White Hill Wind Farm

Annex 1.5: Scoping Response from Kilkenny County Council

The applicant is advised of the opinion of Kilkenny County Council as follows in response to Scoping Document received on 27th April 2021 as part of pre-planning consultation process for Wind Farm development for Whitehill Windfarm':

**Figure 13: Site Entrance on N78 & L1834**

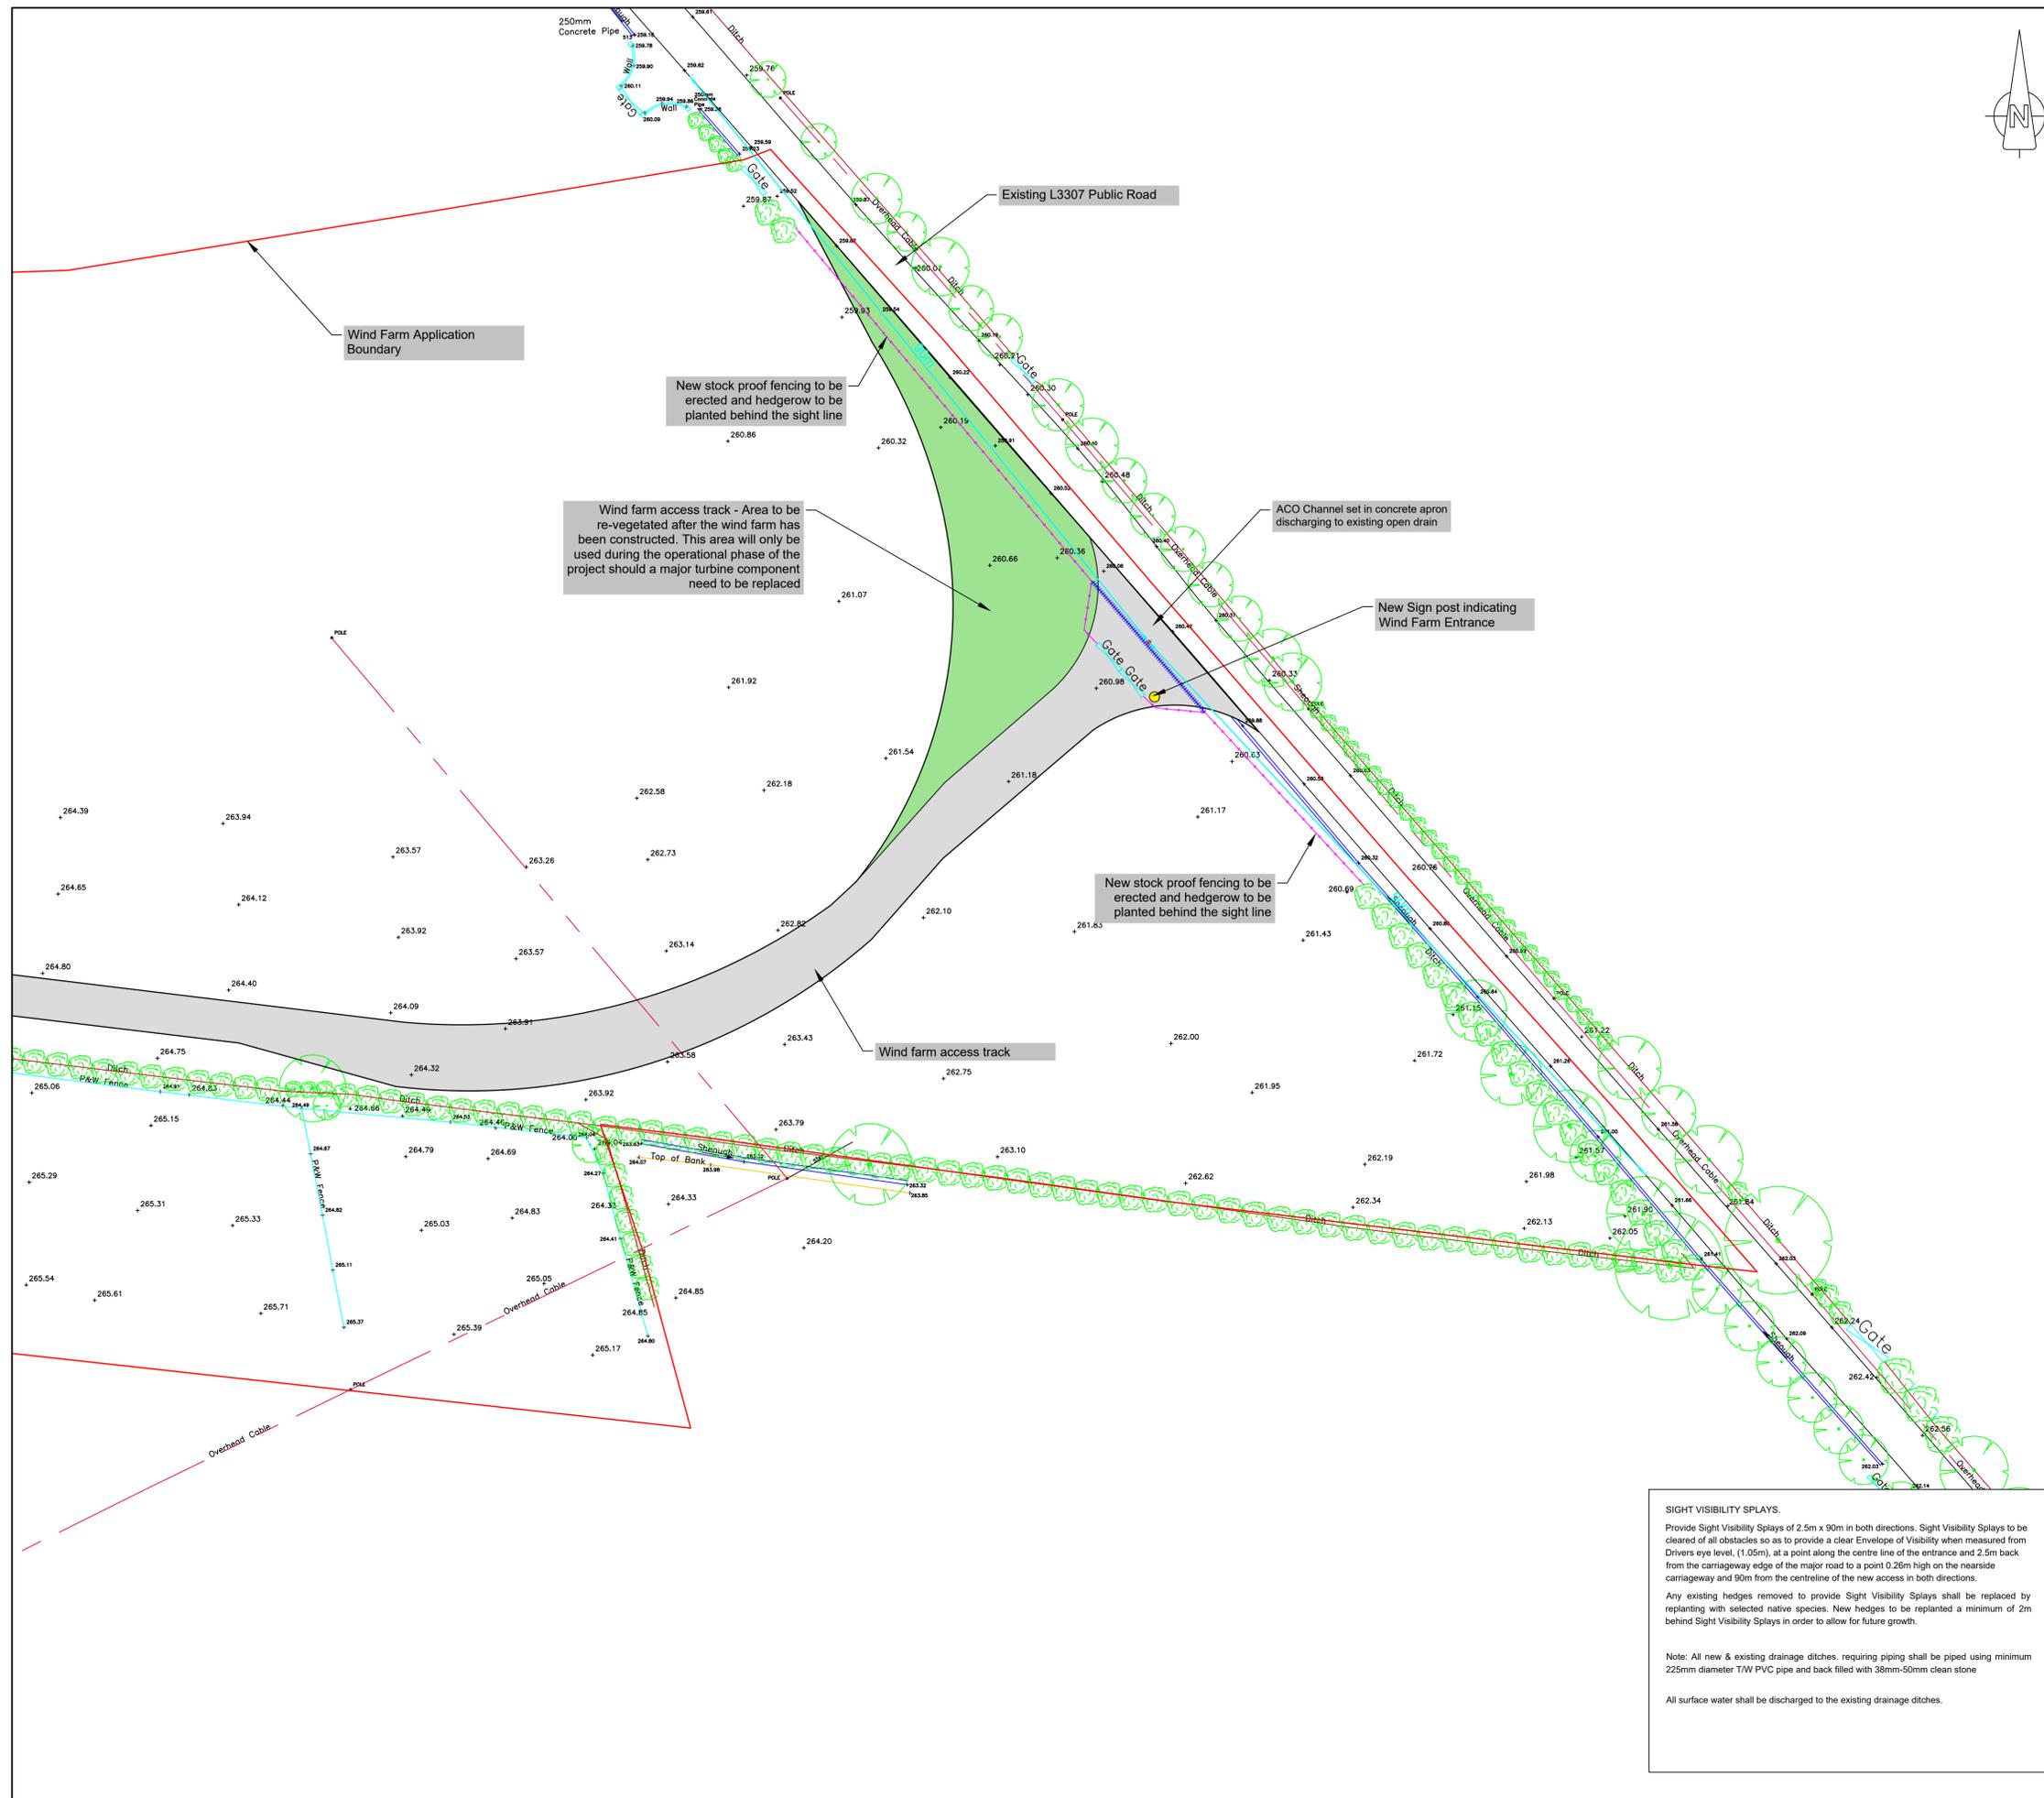
The EIAR Scoping Report also outlines that it is proposed to construct a temporary access at the junction of the N78 and L1834, to accommodate the delivery of abnormal-sized loads as the current junction is not capable of accommodating such loads. It is stated that the construction of the temporary access will be fully reinstated immediately following the delivery of turbine components.

As noted above, designers should consult TII Publications to determine whether a Road Safety Audit is required for any of the temporary works proposed. Any recommendations should be incorporated into designs.

Additionally, any damage caused to the pavement on the existing national road at the temporary access due to the turning movement of abnormal 'length' loads (e.g. tearing of the surface course, etc.) shall be rectified in accordance with TII Pavement Standards and details in this regard shall be agreed with the Road Authority prior to the commencement of any development on site.

- Routes for construction traffic
- Route Selection for Abnormal Loads
- Temporary junction at N78/ L1834 (Moneenroe Cross) and access road link to L1834 (including consultation with TII)
- Assessment of local road route along L1834 & L1837 to Carlow Co Bounds
- Assessment of local network to consider pavement condition, structures, road width restrictions, overhead services and identification of other constraints
- Structural pavement analysis (Fall Weight Deflectometer Pre and post works) and recommendations
- Visual and photographic record for pre and post works phases to monitor road condition and damage arising from works
- Traffic Management Plans
